**RHS COMMENTS ON REP8-022 UPDATED SOCG
BETWEEN NE AND HE (STILL DATED MARCH 2020)**

Project Title	M25 Junction 10/A3 Wisley Interchange
Drawing Title	FIGURE 13 SPA COMPENSATION, SPA ENHANCEMENT AND REPLACEMENT LAND PROPOSALS
Drawing Number	HE551522 - ATK - ELS - XX_ML - DR - LE - 001003
Location	
Original Size	A1
Scale	1:2500
Project Ref. No.	5158141
Sheet	3 of 10
Rev	P01.1

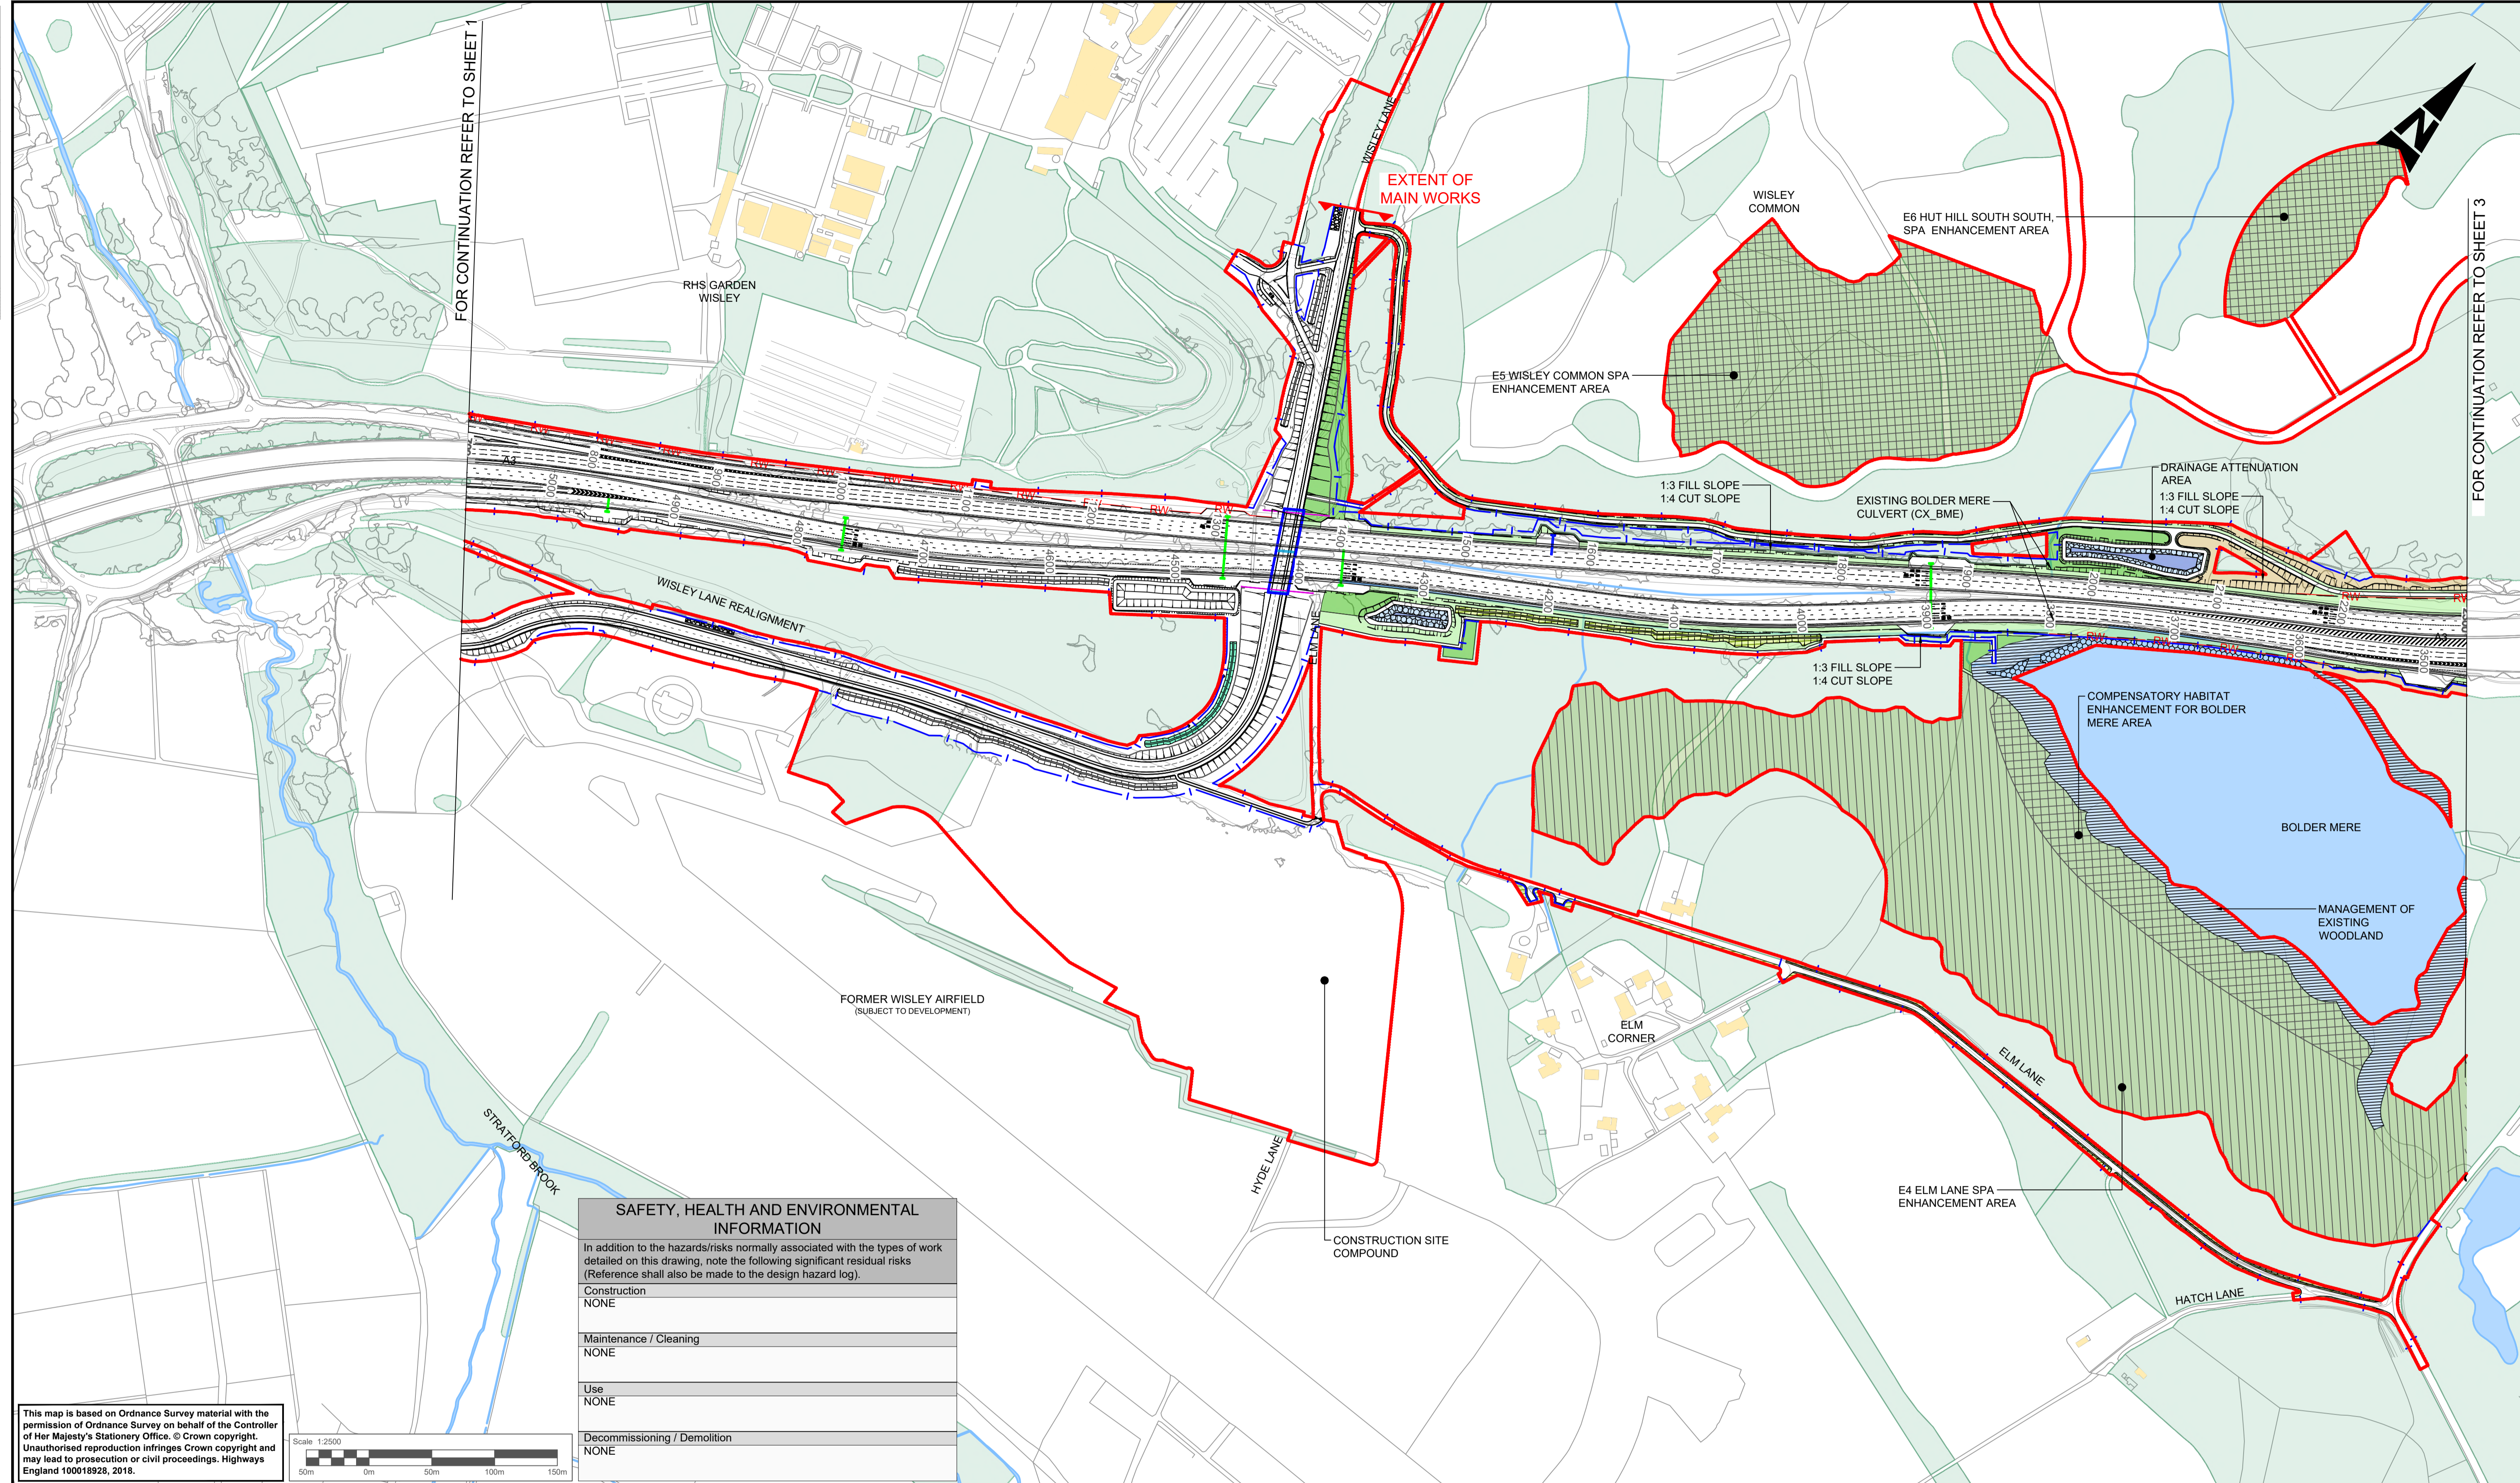
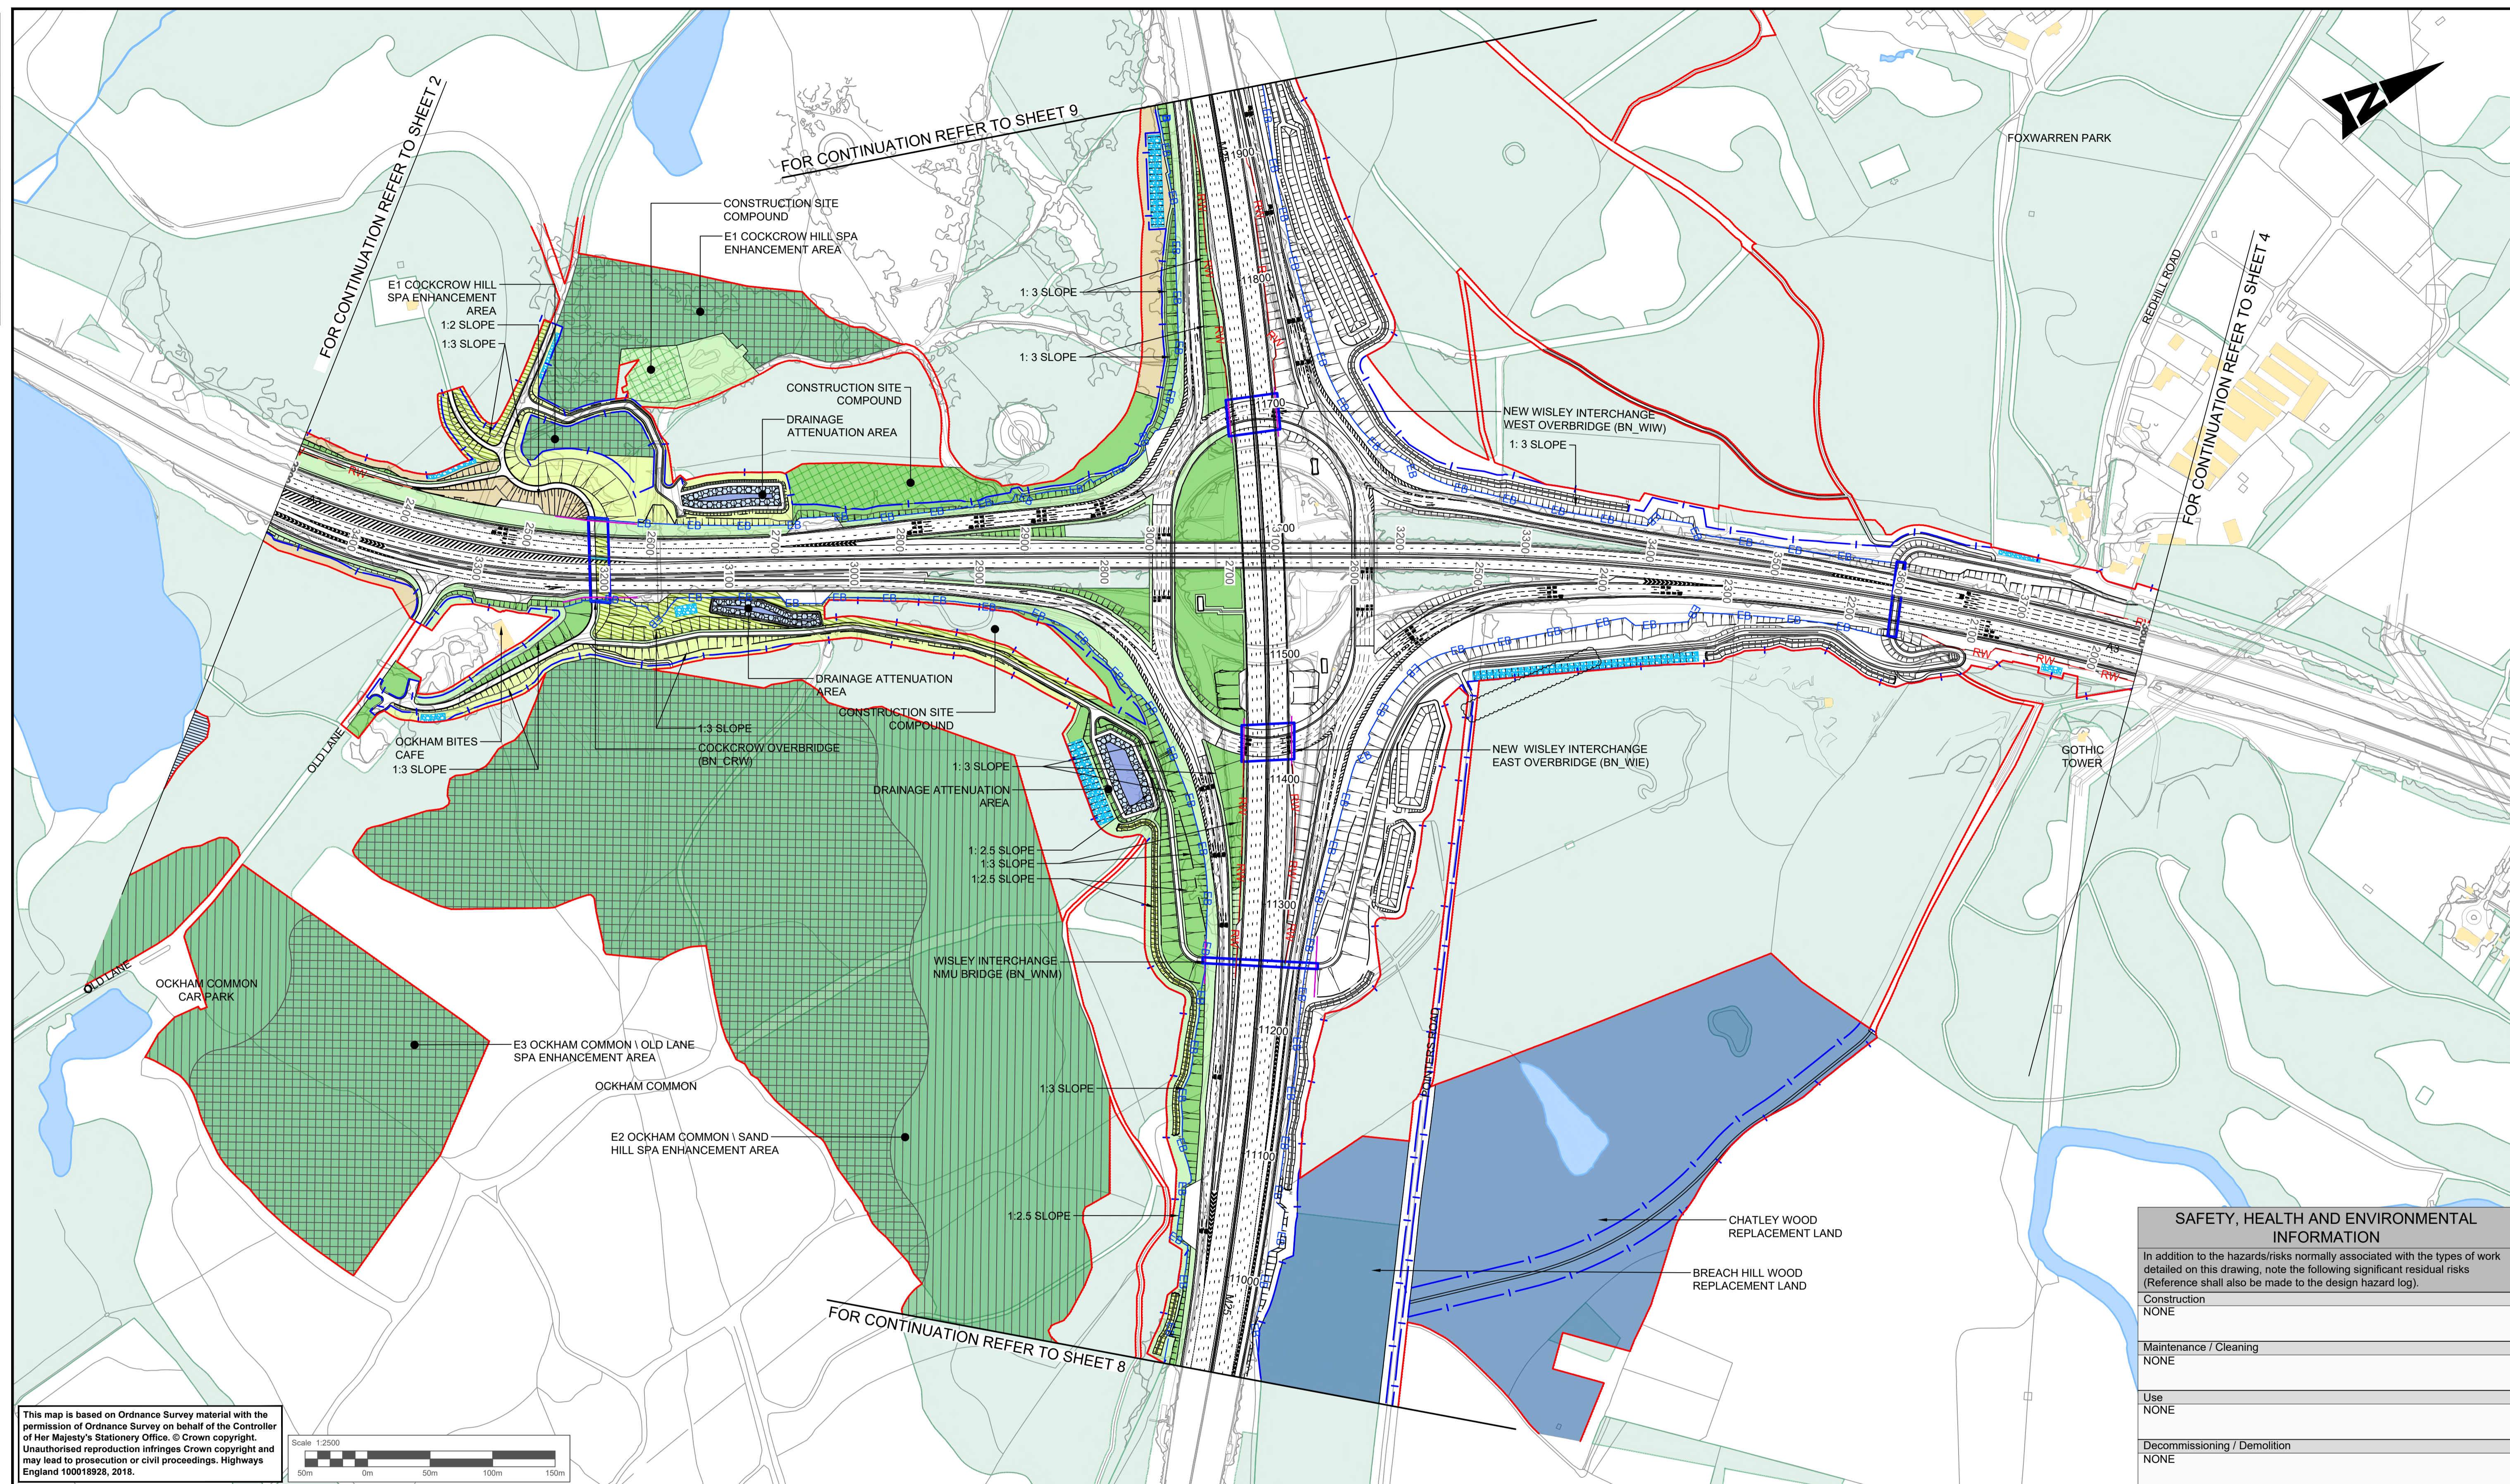
“As explained in 3.2.17 above, Natural England were consulted on and agreed with the suite of compensatory measures. The Suite of compensatory measures will retain the woodland buffer, with the exception of an area of woodland clearance either side of the proposed green bridge (areas E1 and E2 as shown in Figure 13 of the HRA figures [AS-006]). This is in order to maximise the effectiveness of this green bridge, and it has been agreed with Natural England. It is acknowledged that this newly created area of heathland closer to the A3 would be exposed to higher levels of nitrogen deposition than the existing areas of heathland and may require a greater level of management”.

32. The above statement does not accord with the Figure AS-012 rev 2. In Figure AS-012 it is clear that there are large areas of SPA woodland buffer <150m from the roads which will be SPA enhancement areas. These areas will either be thinned out or lost as the land is converted to heathland as set out in HE's REP4-014.
33. Therefore, in fact much larger areas of heathland (than HE is conceding here) will be affected by higher levels of nitrogen deposition since these areas are located within the SPA <150m from the roads. This does indeed throw in doubt the NE / HE assertion that *“the clearance of select areas of the woodland buffer as part of the suite of compensatory measures does not conflict with NE's conservation objectives for the TBH SPA”* (3.2.18 SoCG).
34. HE and NE then state:

“In addition, the SPA enhancement area E5 also requires some clearance of the woodland buffer between the heathland and the A3. However, there will still be a retained belt of approximately 75m of woodland at this location separating the heathland from the A3 and this belt of woodland will continue to provide a buffer function.”
35. RHS has measured this area from Figure AS-012 rev 2 and makes it 50m, not 75m. Again this E5 area of proposed compensatory heathland will also be affected by higher levels of nitrogen deposition since it is located within the SPA <150m from the roads.
36. RHS refers to its REP8-054, paragraphs 96-108, where RHS explains why, given the absence of adequate air quality data provided by HE for the SPA zone <150m from the roads, the requirement for technical feasibility of the HE compensatory measures is not met.
37. HE and NE then state:
